From: Laura Gibbons
Sent: 20 June 2018 14:52
To: Planning.Responses
Subject: RE: Planning Consultation on: BN/22/18/PD

Engineers Comments Relating to Surface Water Drainage

APPLICATION BN/22/18/PD

Description of Works: Notification for Prior Approval under Class Q for a Proposed Change of Use of Agricultural Building to 2No. Dwellinghouses (Class C3) and associated works

Block Plan

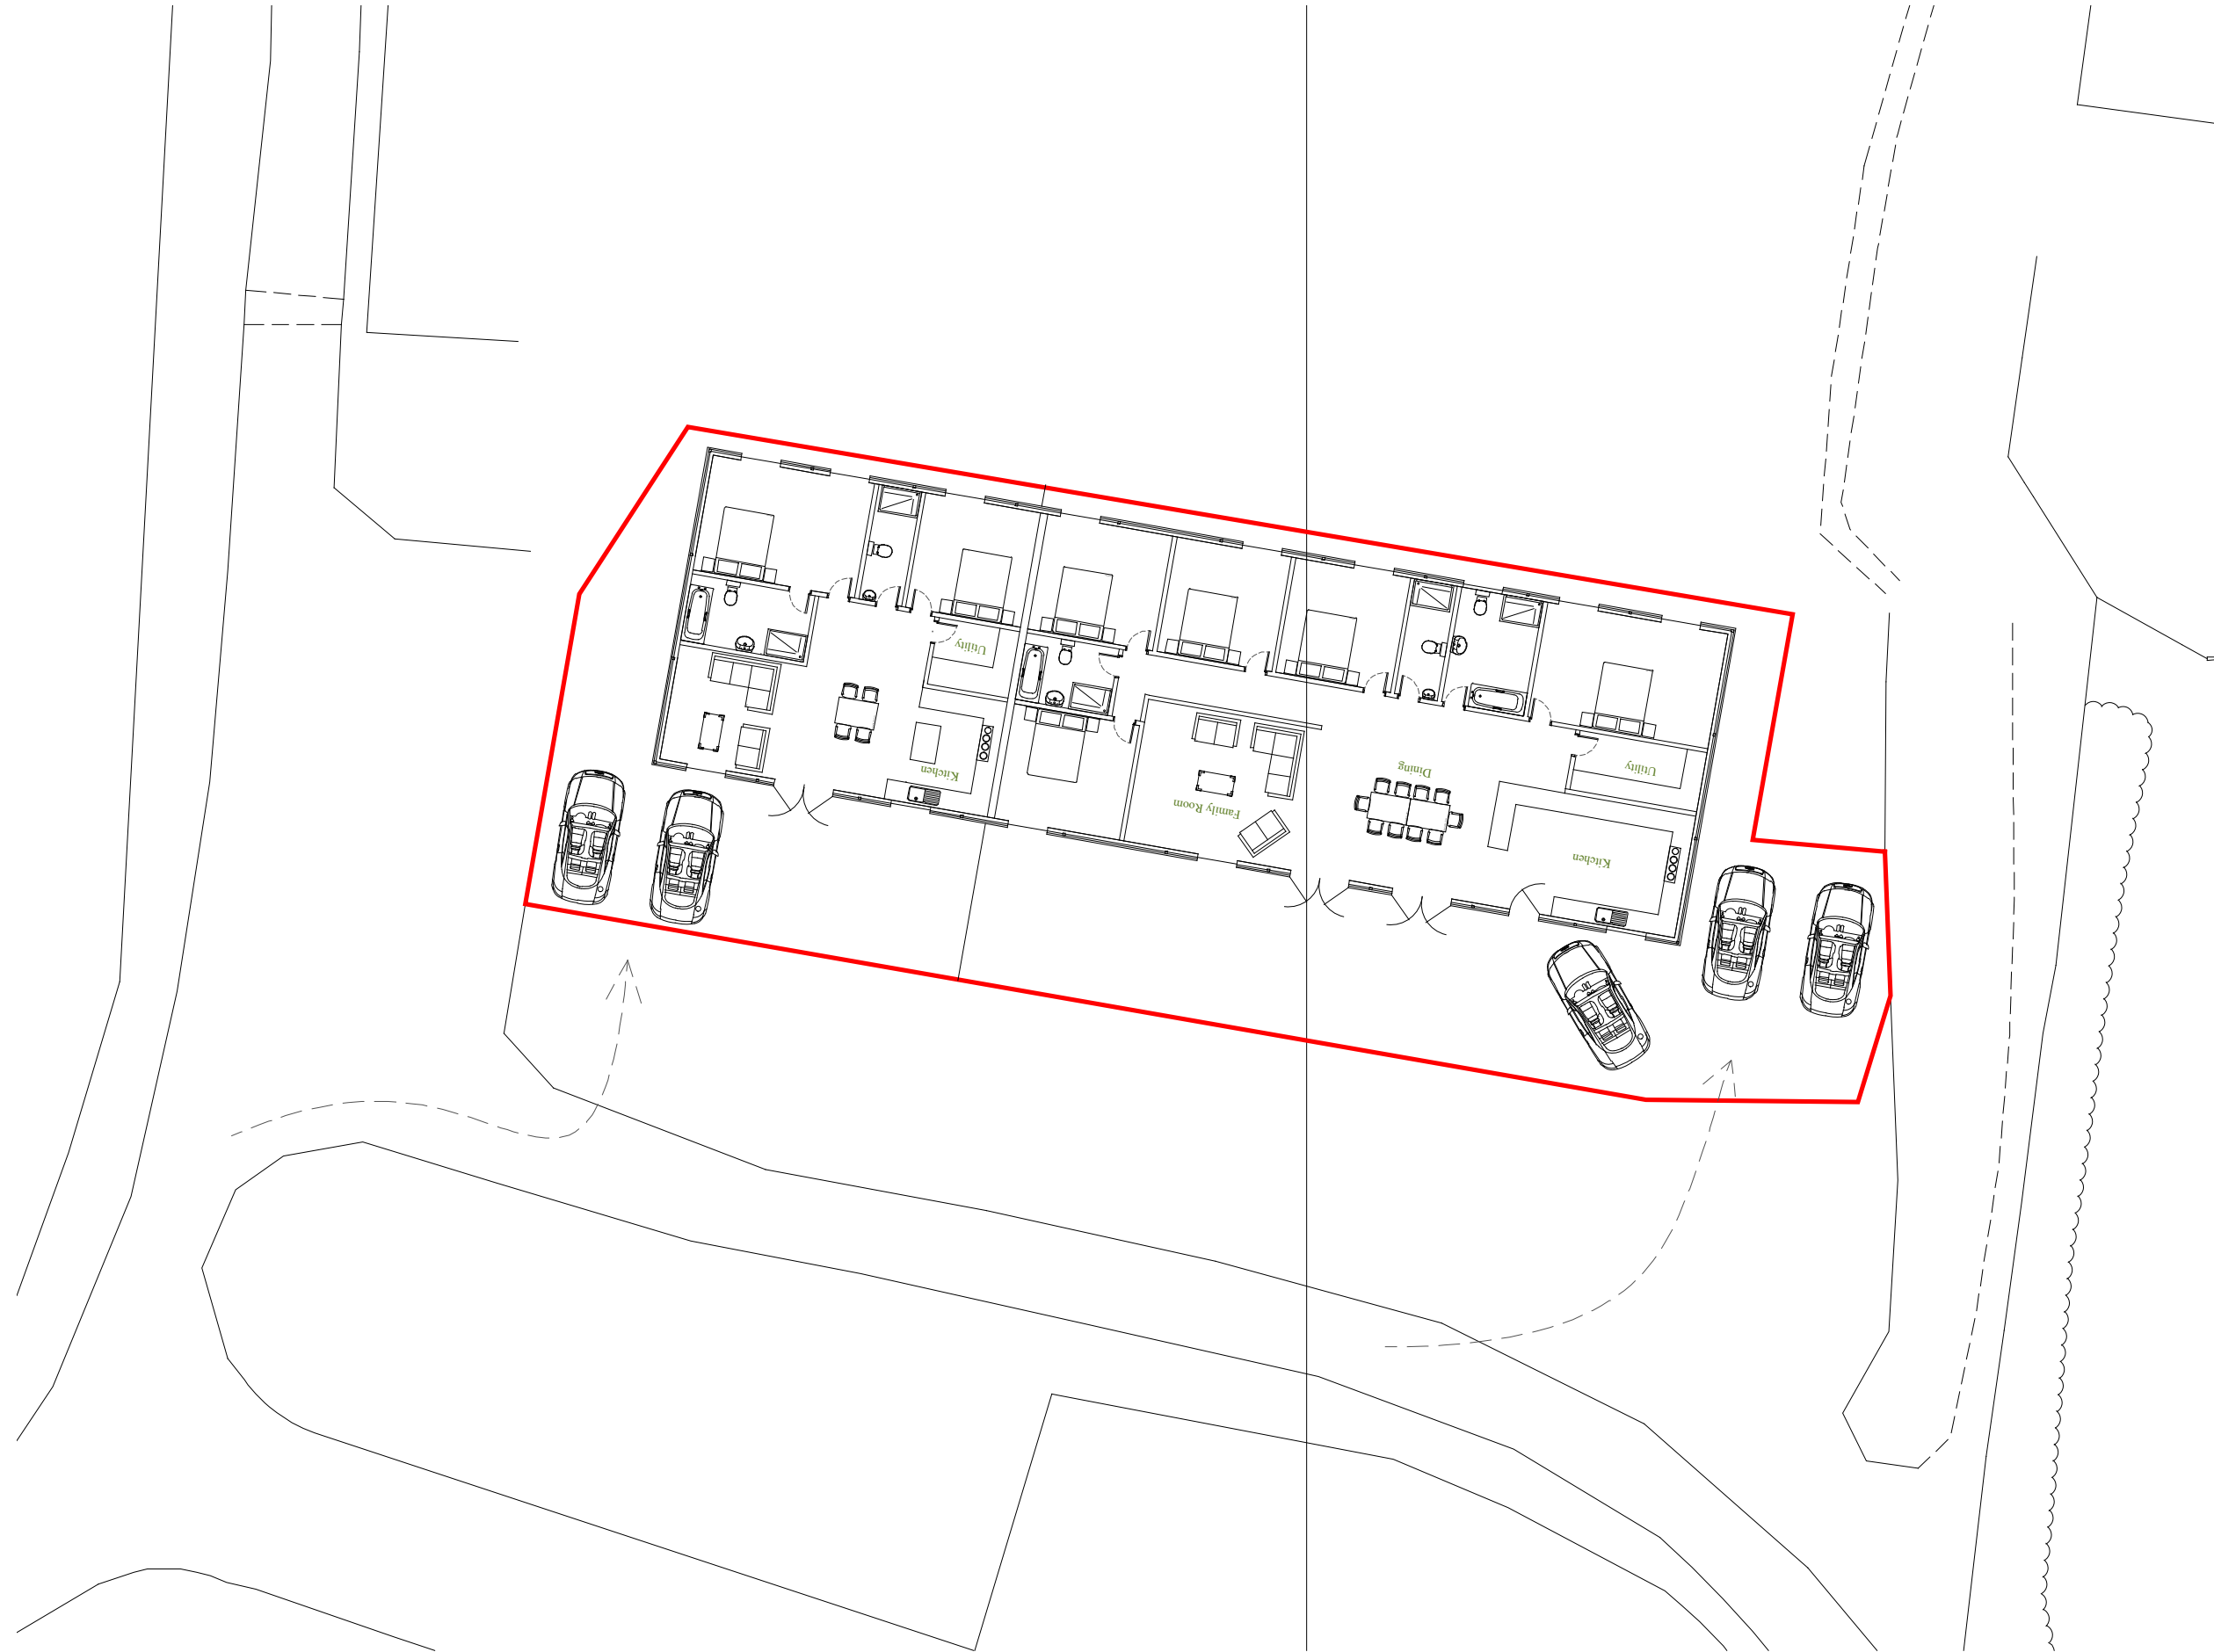
It should be noted that the site is near to an area of historic flooding along Yapton lane. And an area of high surface water flood risk is present within the site boundary to the east, where it is unclear if a drainage ditch network existed. Any proposals to increase hard standing or encroach in this area will need careful discussions with us.
